**Atlas-Campaspe Mineral Sands Project**  
**Responses to the Department of the Environment Review Comments (dated 30 August 2013)**

**1.1.1 Commonwealth Government (30 August 2013) states:**

**FIGURE 2-7**

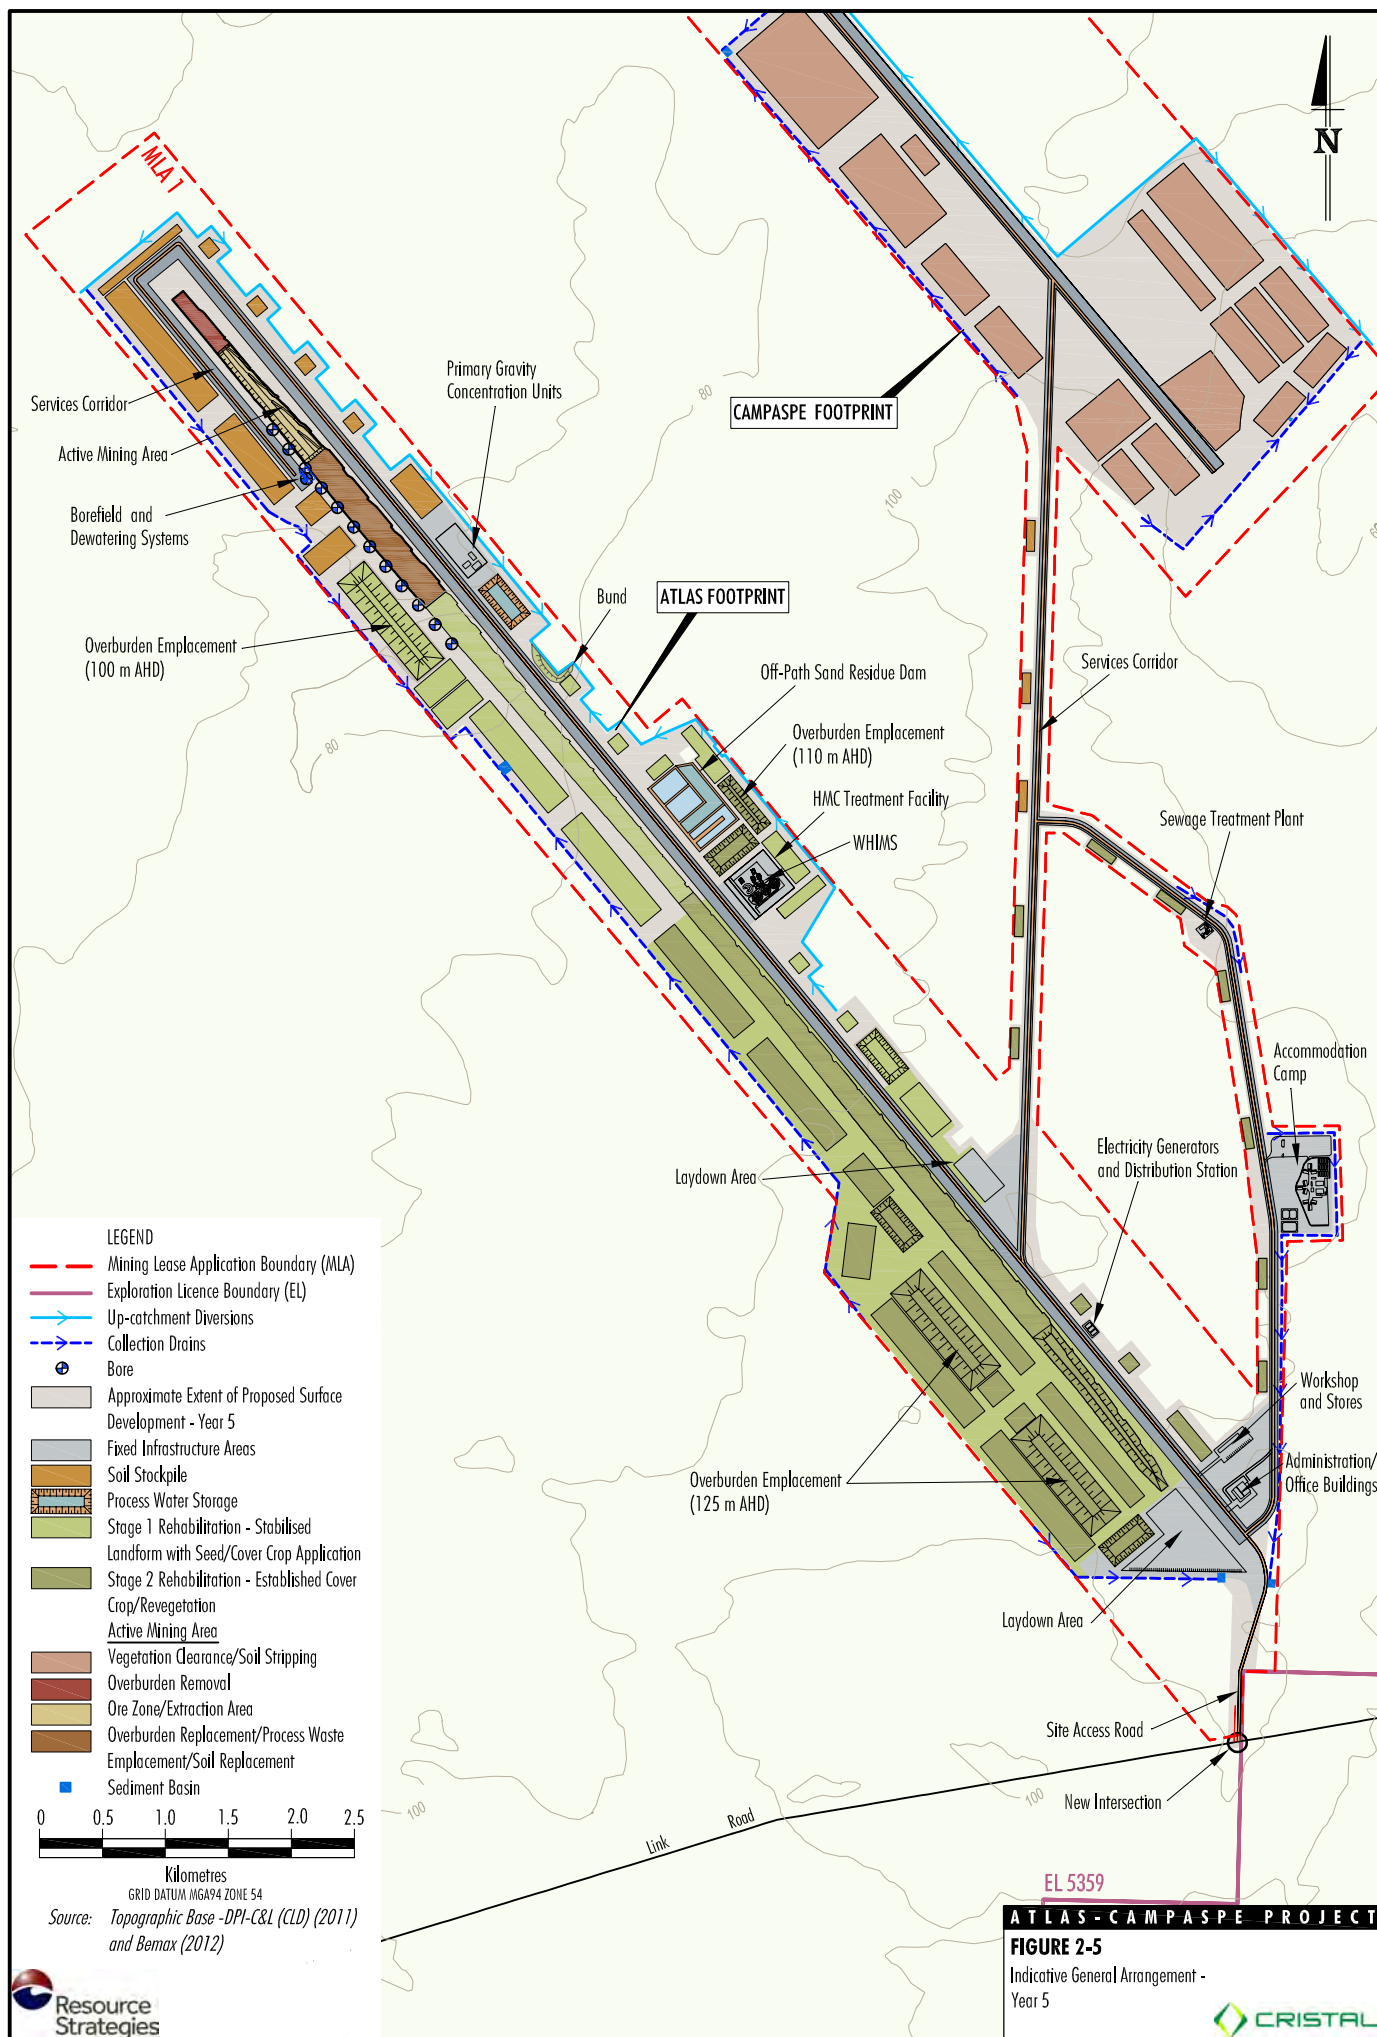
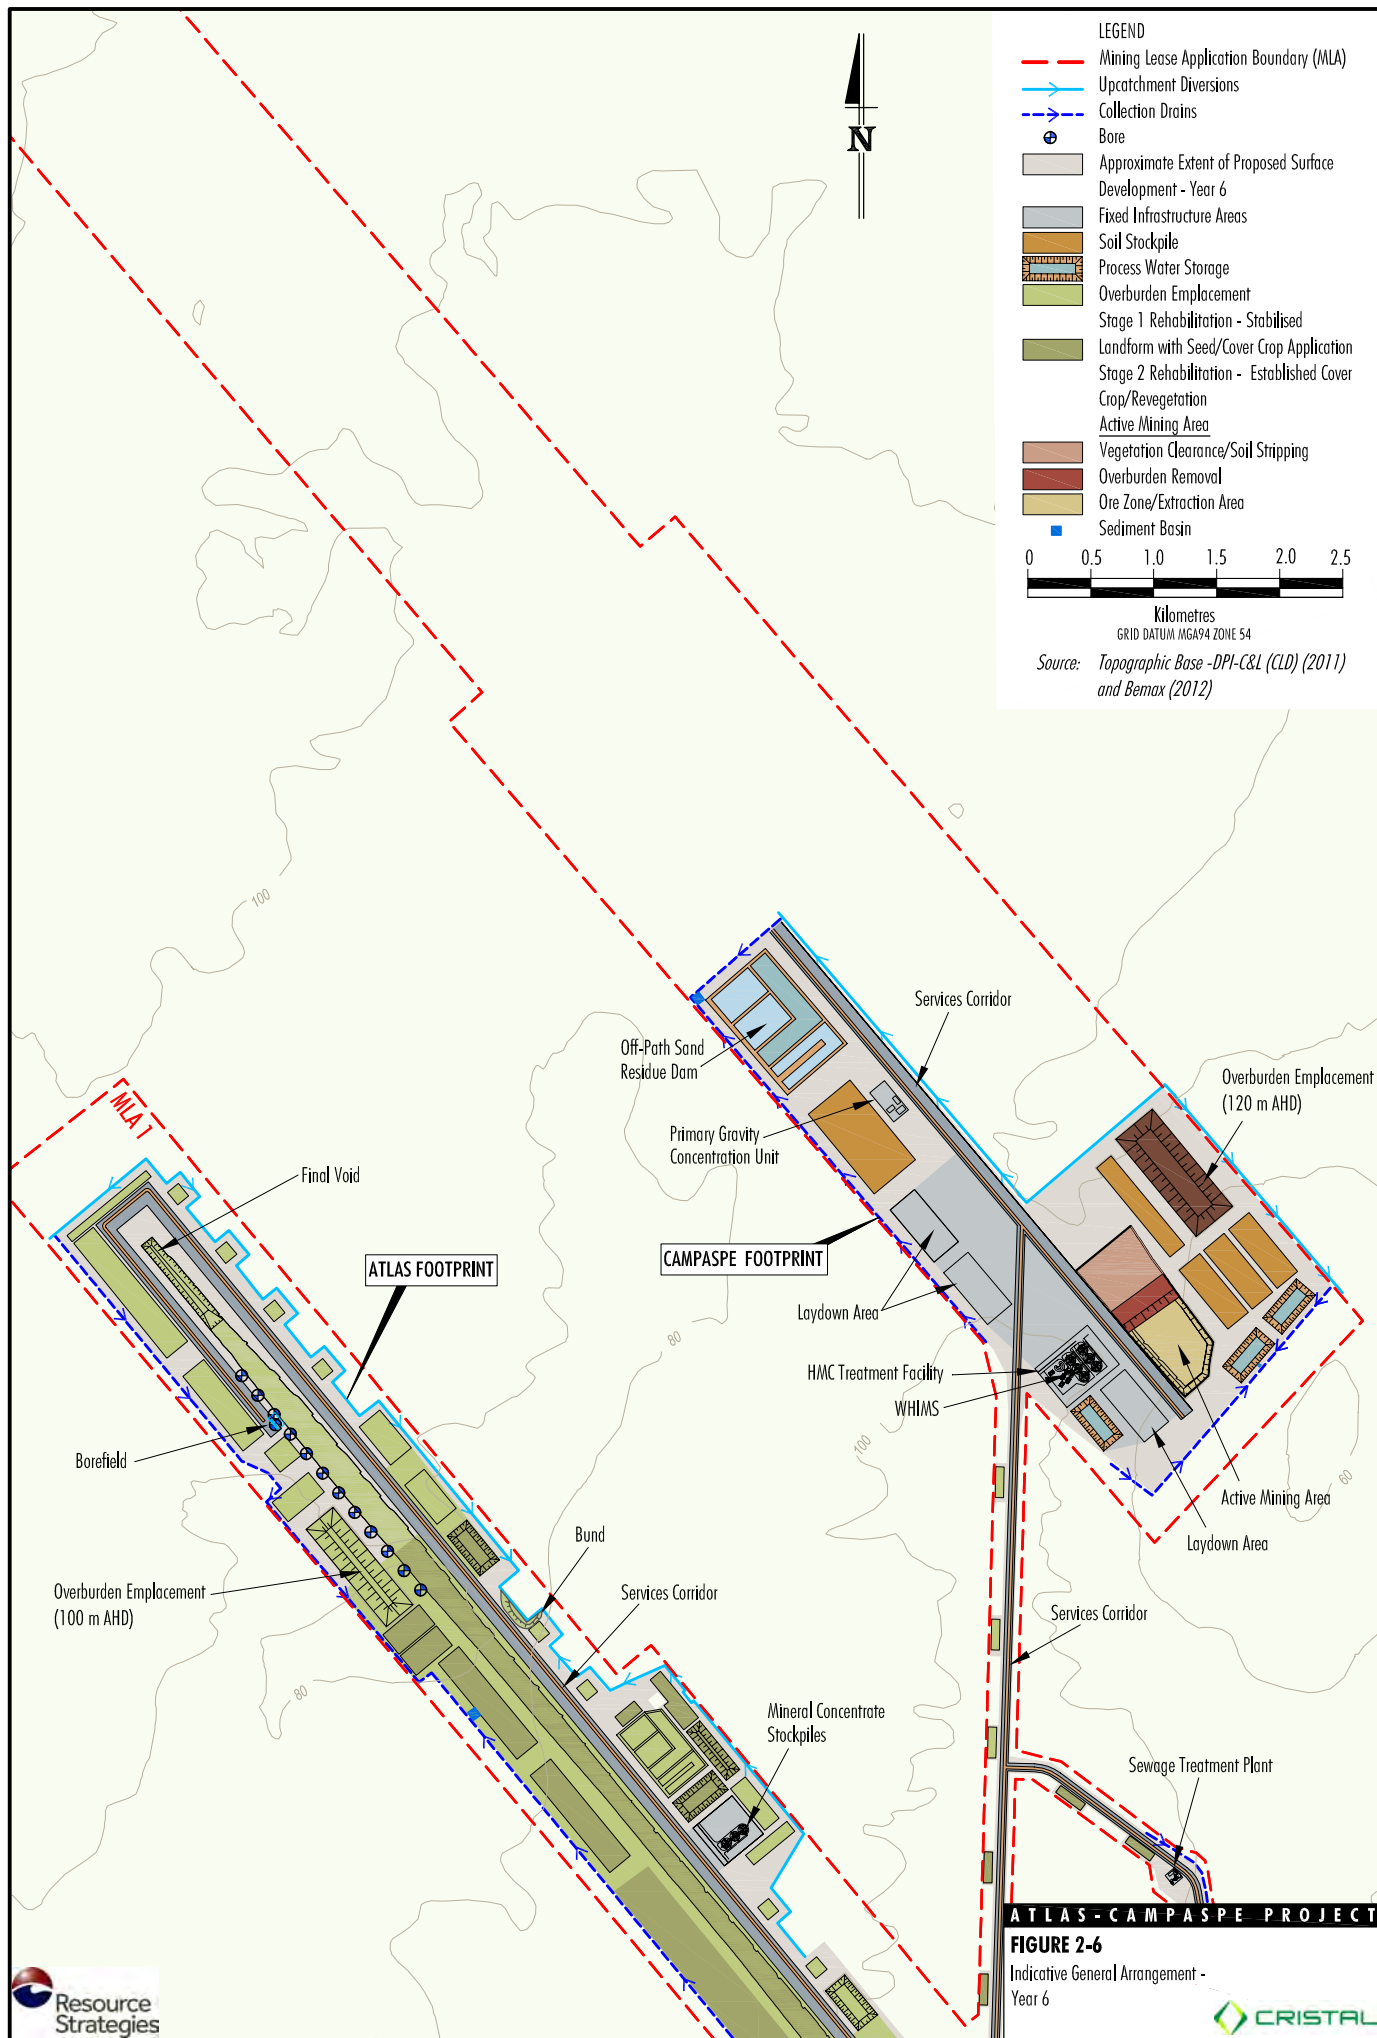
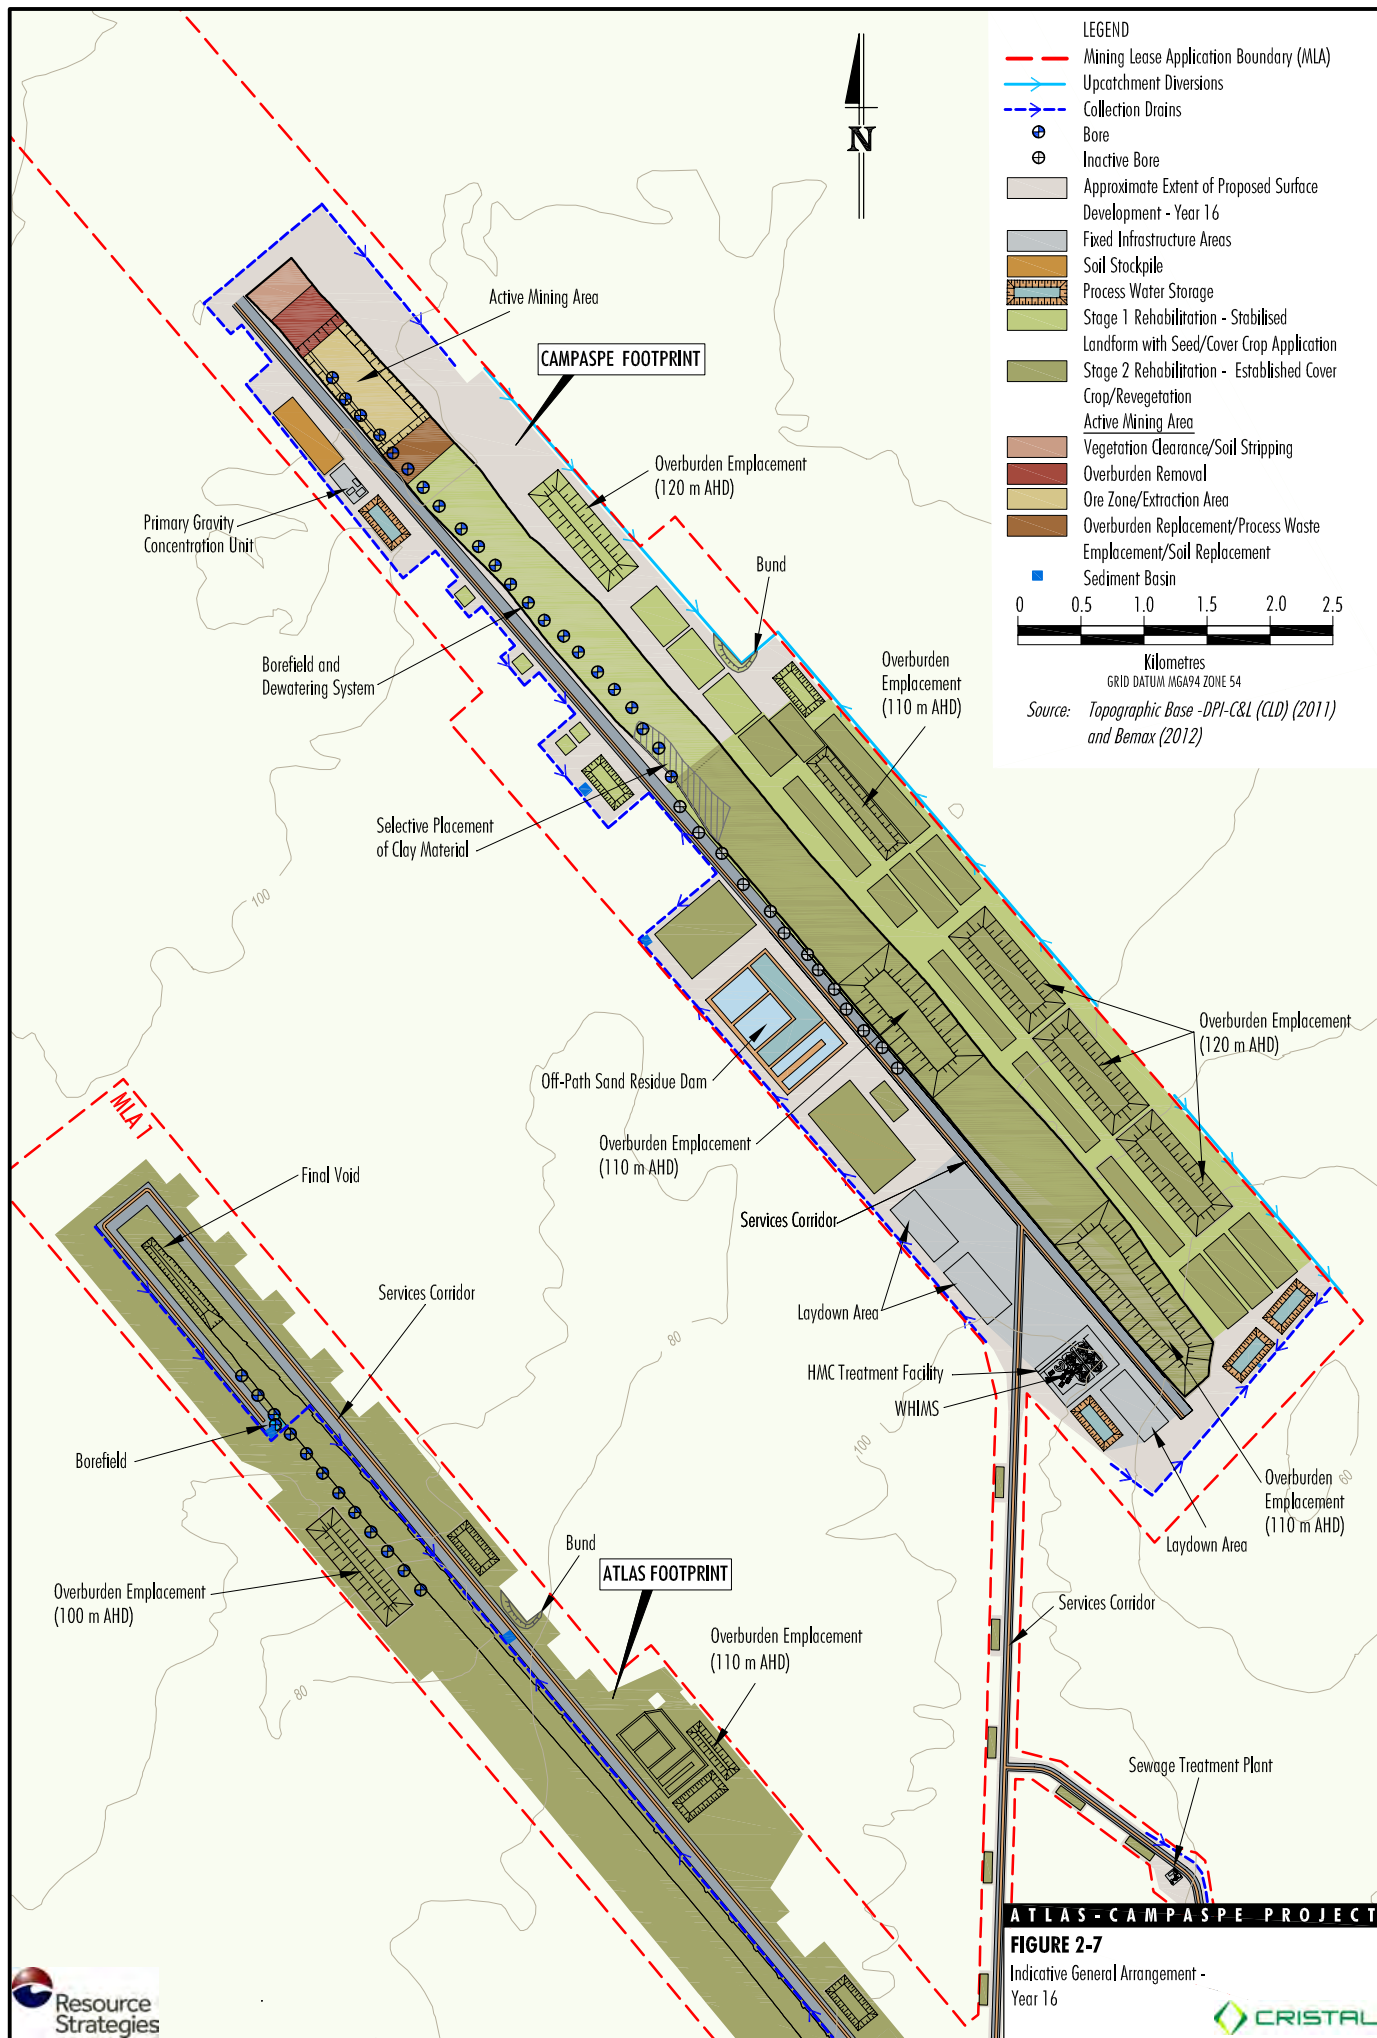
***Further detailed information about the proposed staging of rehabilitation works and how these relate to the timing and location of the advancing void is still required. Although the Department notes that these are depicted in the figures, we request further information about the timing of commencement of rehabilitation at particular areas in regards to the stage of extraction, and the progression of rehabilitation works in relation to the progression of the mine void.***

Rehabilitation would occur progressively over the 20 year life of the mine as shown on Figures 2-4 to 2-8 of the EIS. Mining areas (e.g. overburden emplacements and the backfilled mine path) would be rehabilitated as they are no longer required for mining operations and other mine infrastructure is rehabilitated as it is decommissioned.

Landform preparation (i.e. replacement of overburden, subsoil and topsoil) on mining areas would commence within three months of the area becoming available for rehabilitation (i.e. the area is no longer required for mining operations) (subject to favourable climatic conditions).

Revegetation of mining areas would commence within 12 months of the area becoming available for rehabilitation (i.e. the area is no longer required for mining operations) (subject to favourable climatic conditions). Revegetation activities would be conducted on an annual basis during late autumn/early winter (i.e. prior to the winter rains) to maximise the potential for successful revegetation.

Table 3 provides further detail regarding the timing of commencement of rehabilitation at particular areas in regards to the stage of extraction, and the progression of rehabilitation works in relation to the progression of the mine void.

Year	Approximate Area (ha) of Rehabilitation (as shown on Figures 2-4 to 2-8 of the EIS)	Location of the Active Mining Area (as shown on Figures 2-4 to 2-8 of the EIS)
2	0	Southern end of the Atlas Footprint
5	360	Northern end of the Atlas Footprint
6	610	Southern end of the Campaspe Footprint
16	2120	Mid-way along the Campaspe Footprint
20	2330 (+ 600 ha of Stage 1 rehabilitation)	Northern end of the Campaspe Footprint
